DRB CASE ACTION LOG (SITE PLAN FOR BUILDING PERMIT)

DRB Application No.: 07DRB-70210(SBP)
Project Name: MERIDIAN BUSINESS PARK
Agent: TATE FISHBURN ARCHITECT

3. **Project# 1006771**
07DRB-70210 MINOR - SDP FOR
BUILDING PERMIT

TATE FISHBURN ARCHITECT agent(s) for BRUNACINI DEVELOPMENT request(s) the above action(s) for all or a portion of Lot(s) 17B, **MERIDIAN BUSINESS PARK**, zoned IP, located on UNSER BLVD NW BETWEEN I-40 NW AND CENTRAL AVE NW containing approximately 2 acre(s). (K-10) **THE SITE PLAN FOR BUILDING PERMIT WAS APPROVED WITH FINAL SIGN OFF DELEGATED TO TRANSPORTATION DEVELOPMENT FOR CITY STANDARD DRAWING NUMBERS FOR WORK WITHIN THE RIGHT-OF-WAY, 6-FOOT SIDEWALK AND TO PLANNING FOR LANDSCAPE CALCULATIONS AND 3 COPIES OF THE PLAN.**

1 SITE PLAN
1"=20'-0"

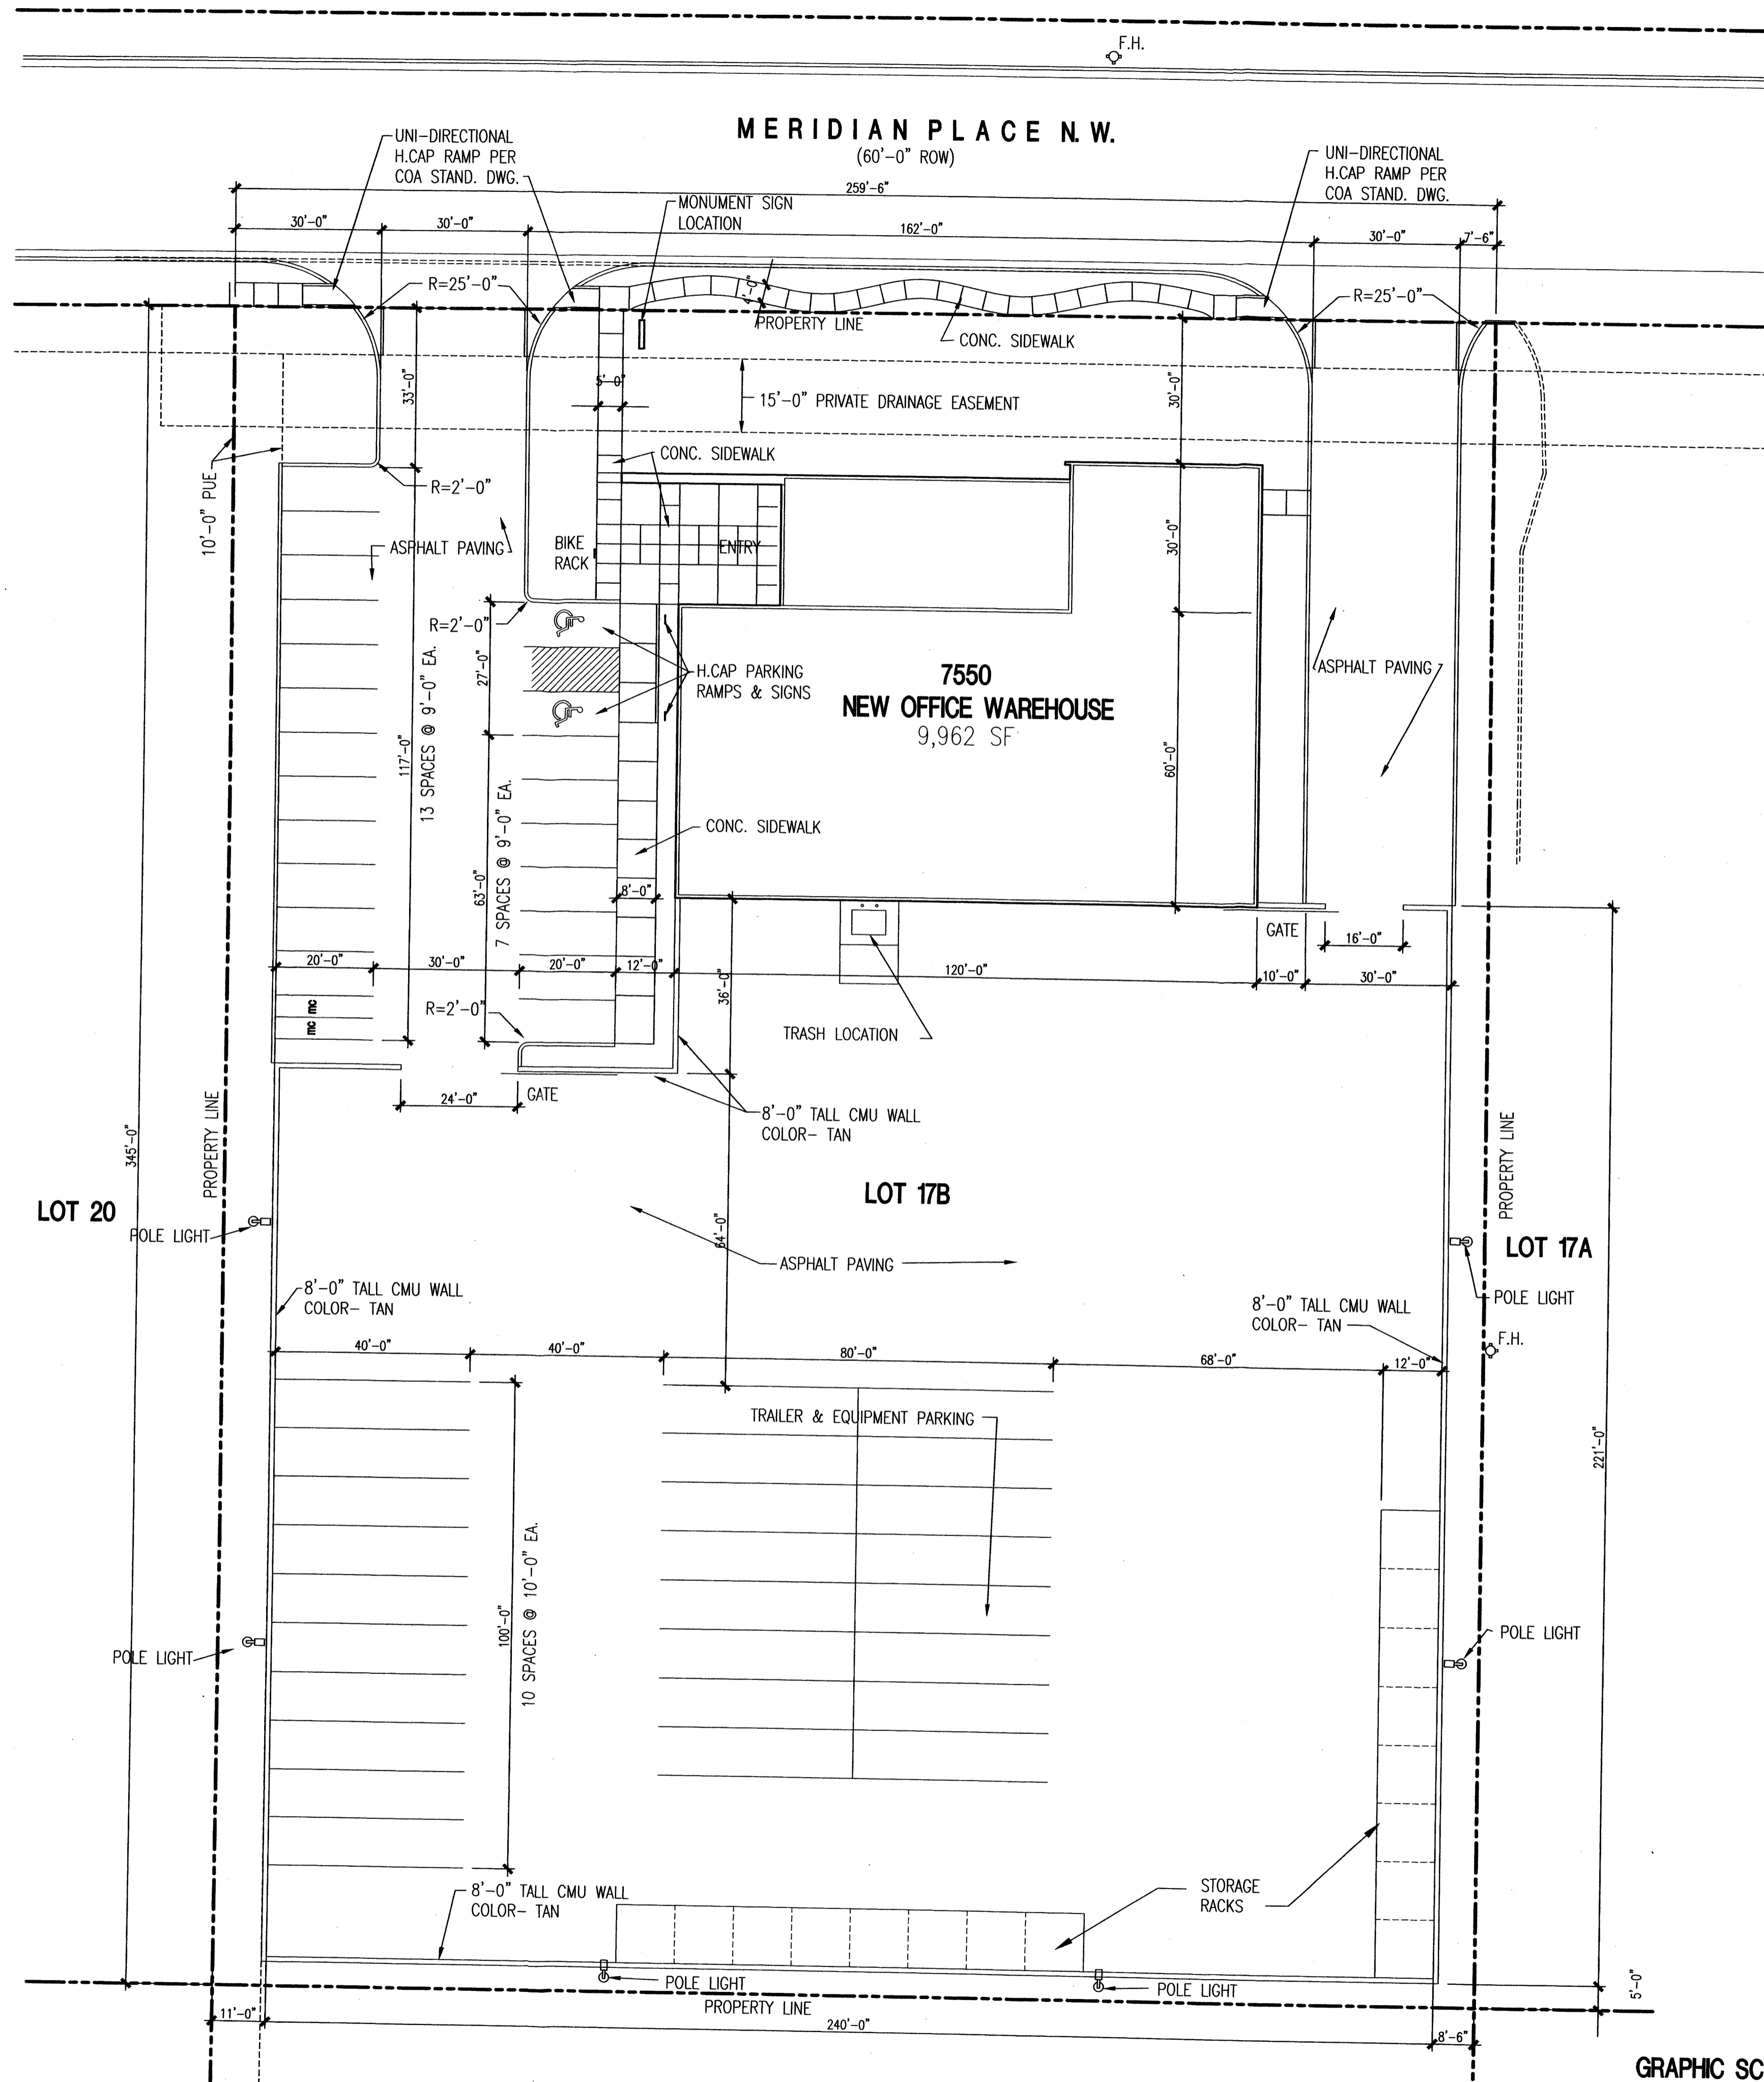
- TRANSPORTATION: City Standard drawing numbers for work
- within right of way
- 6' sidewalk
- (MERIDIAN BUSINESS PARK REQUIRES 4' MEANERING
- SIDEWALK)
- ABCWUA: _____
- _____
- _____
- CITY ENGINEER / AMAFCA: _____
- _____
- _____
- PARKS / CIP: _____
- _____
- _____
- PLANNING (Last to sign): Landscape calculations
- 3 Copies
- _____
- _____

MERIDIAN 17B
ALBUQUERQUE, NM
LANDSCAPE PLAN

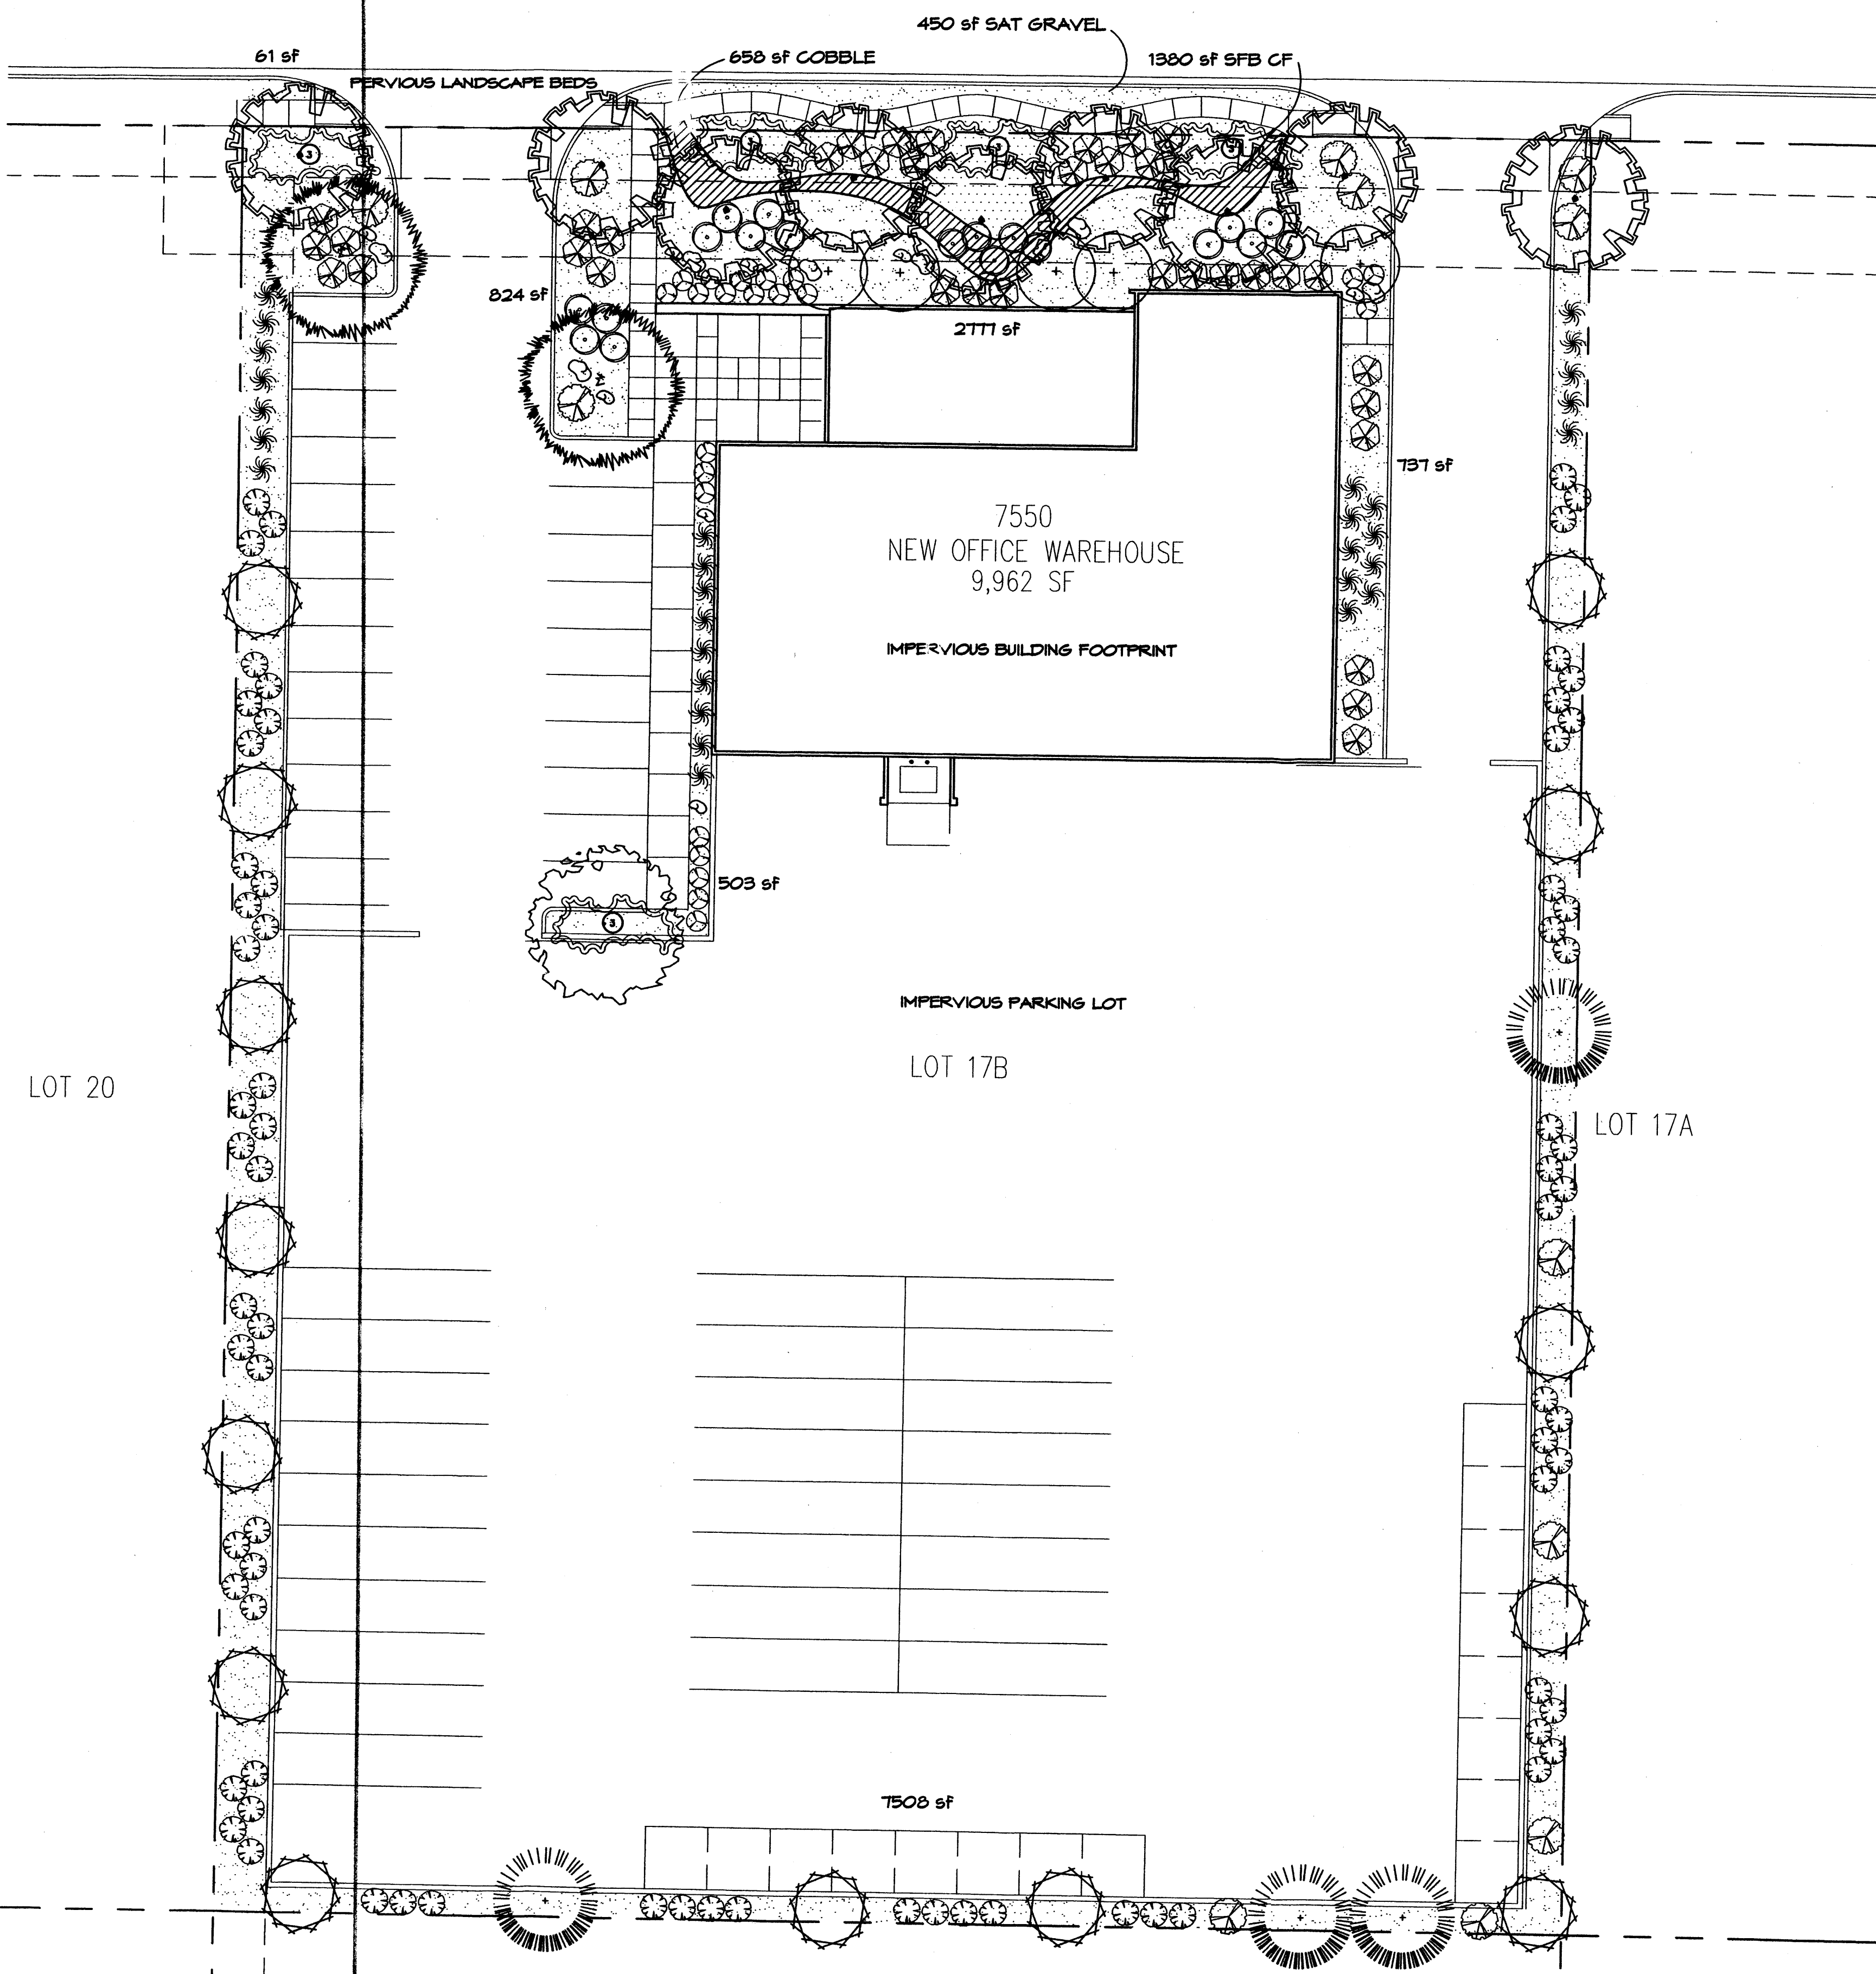
- PLANNING (Last to sign): Landscape calculations
- 3 Copies
- _____
- _____
